A585 Windy Harbour to Skippool Improvement Scheme

7.26 Responses to the ExA's Additional Written Questions and requests for information – ExQ3

**RESPONSES TO THE EXA'S ADDITIONAL WRITTEN QUESTIONS AND
REQUESTS FOR INFORMATION – EXQ3**

Version	Date	Status of Version
Rev 0	September 2019	Deadline 6a Submission

**KEY:**

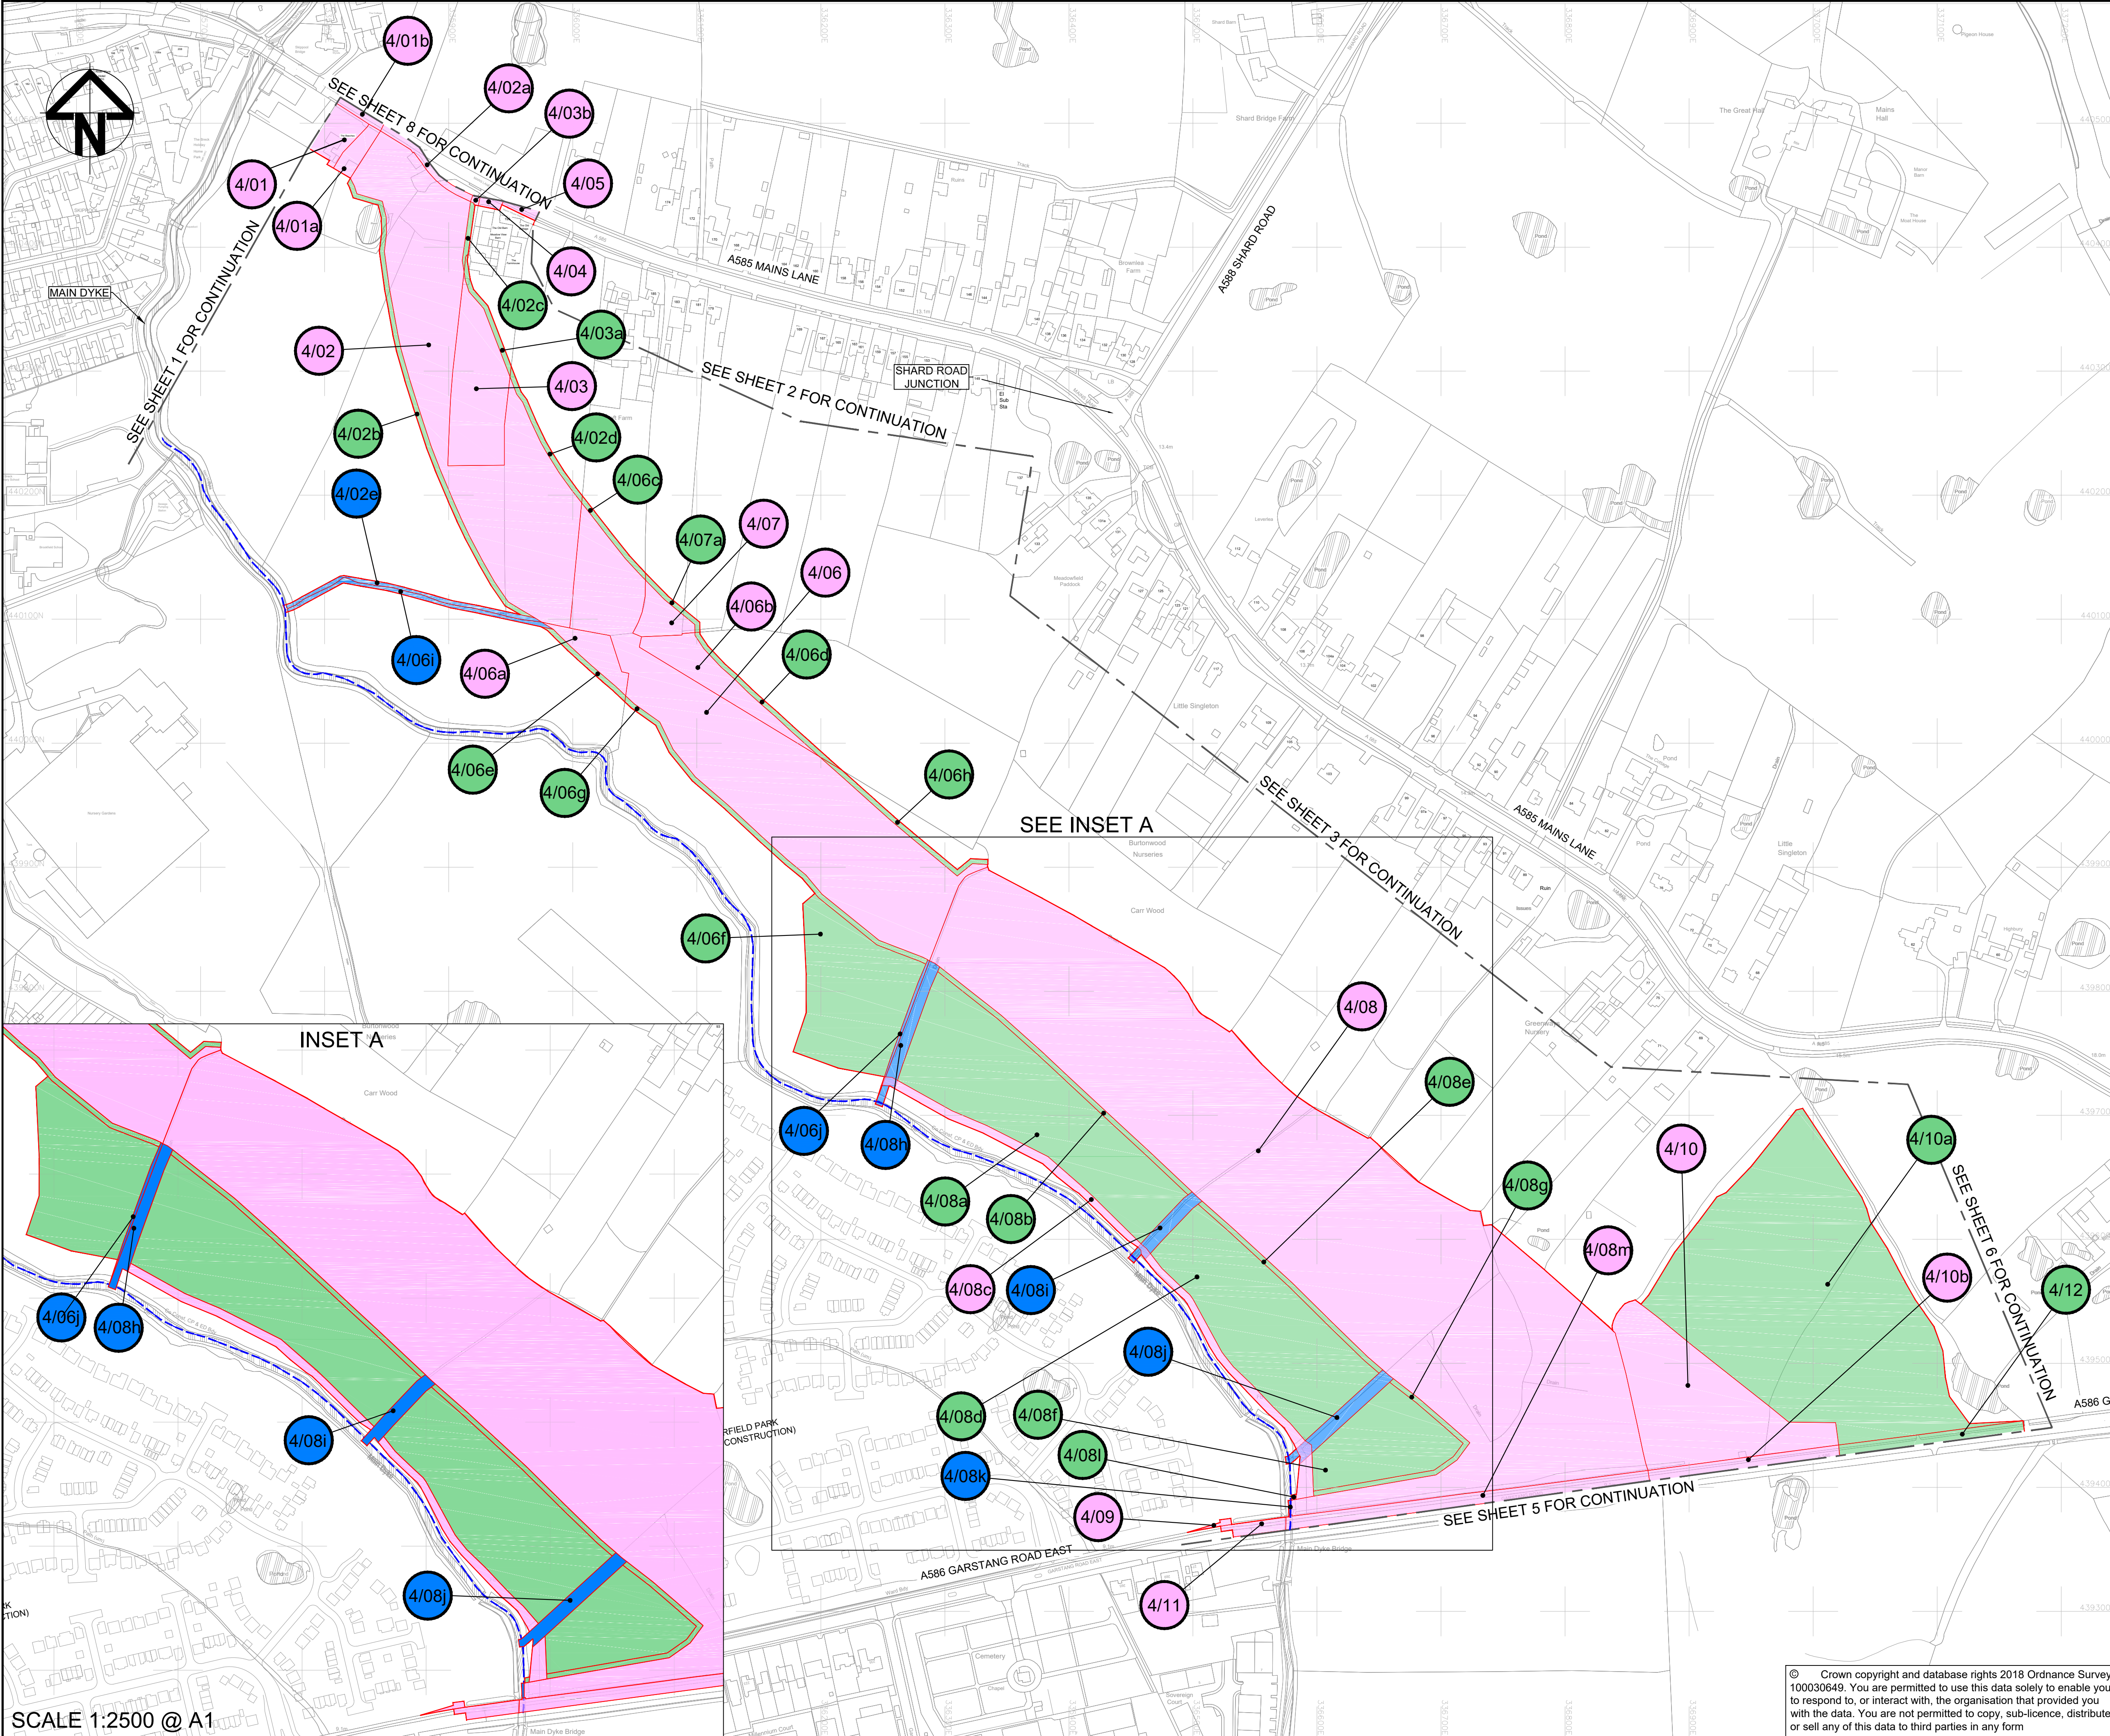
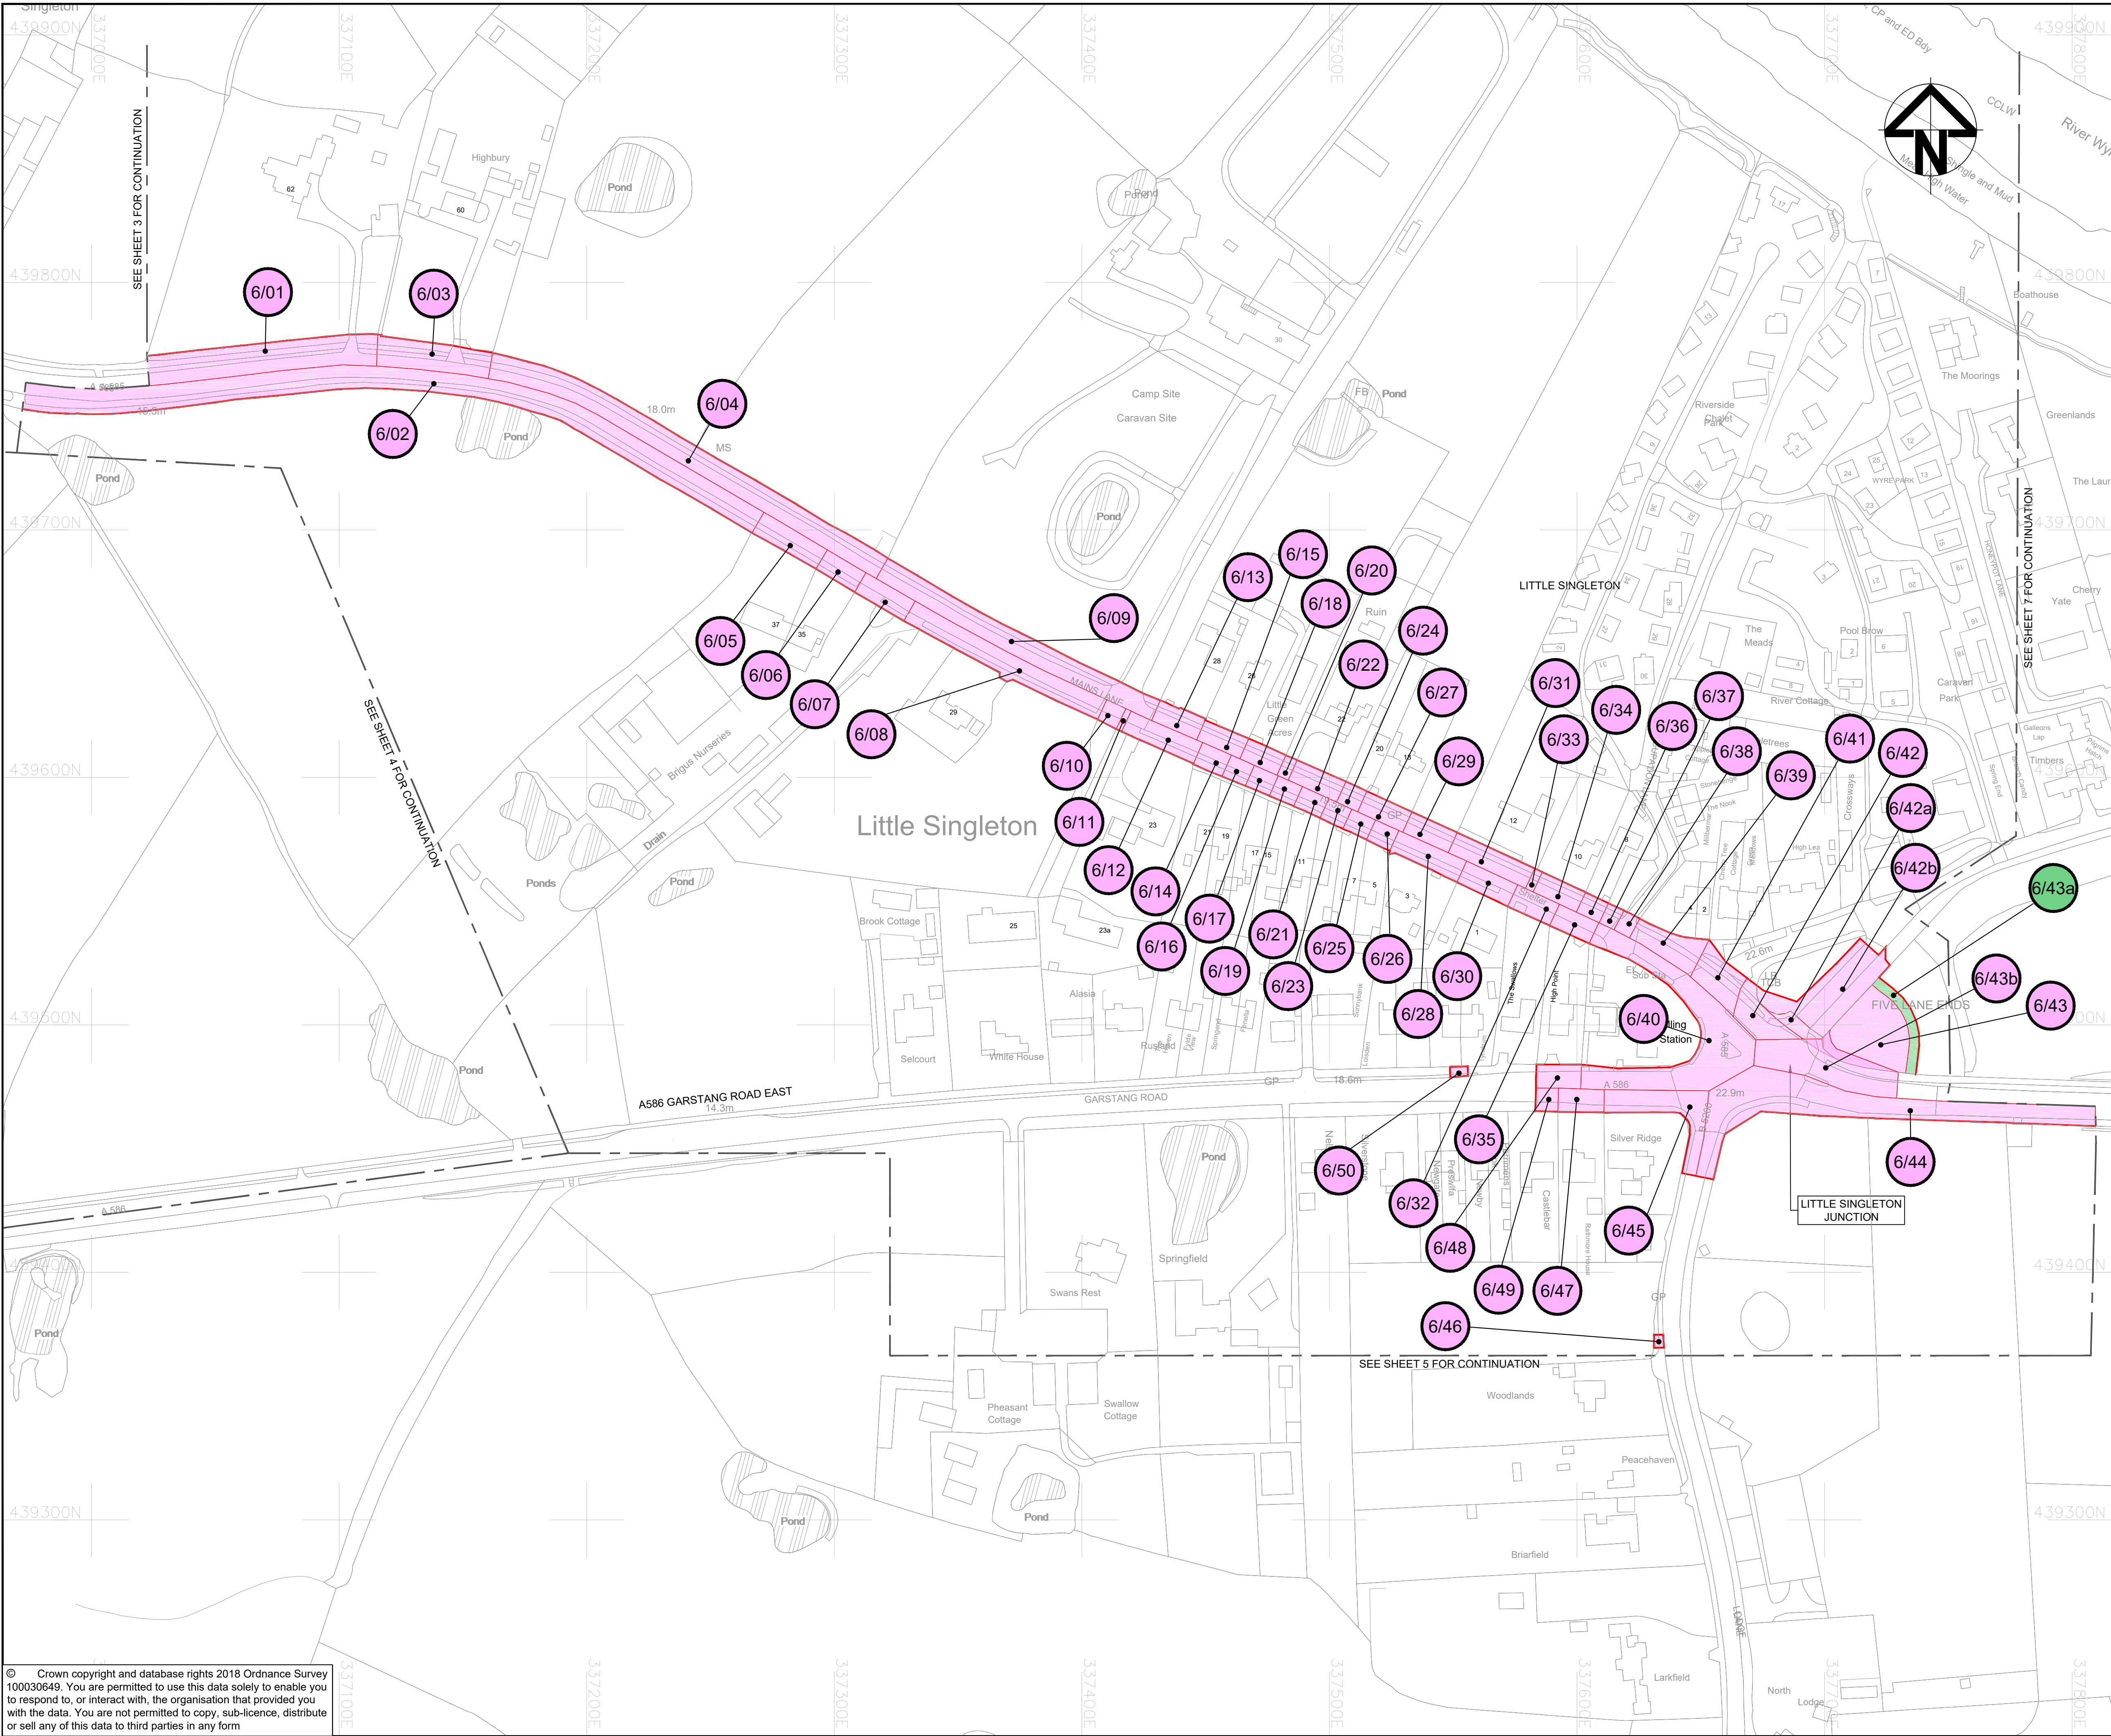
3.2.27	<p>Area not included in the DCO boundary</p> <p>The ExA still does not understand what the land coloured yellow on the plans is for, or why it is identified on the plans at all. The Applicant has not explained this in their response. If the land is not required for any works or required to be acquired permanently or used temporarily why is it highlighted on the plans? It is also confusing for it to have a red boundary if the intention is for this area to be outside of the draft order limits which are defined by a red boundary. Please explain the reasons for the above?</p>	<p>The land coloured yellow is not part of the Development Consent Order and therefore is not required permanently or temporarily to deliver the scheme. [This is explained in the key to the drawings.]</p> <p>This approach is an accepted industry standard method of identifying land which is enclosed by the red lines of the order limits but is not required for the scheme. Other applications have used a similar approach (such as A19 Testos). Colouring the land yellow helps the reader of the plans to easily identify that the land is outside the red lines, something which cannot always be readily seen where there are inner and outer red lines.</p>
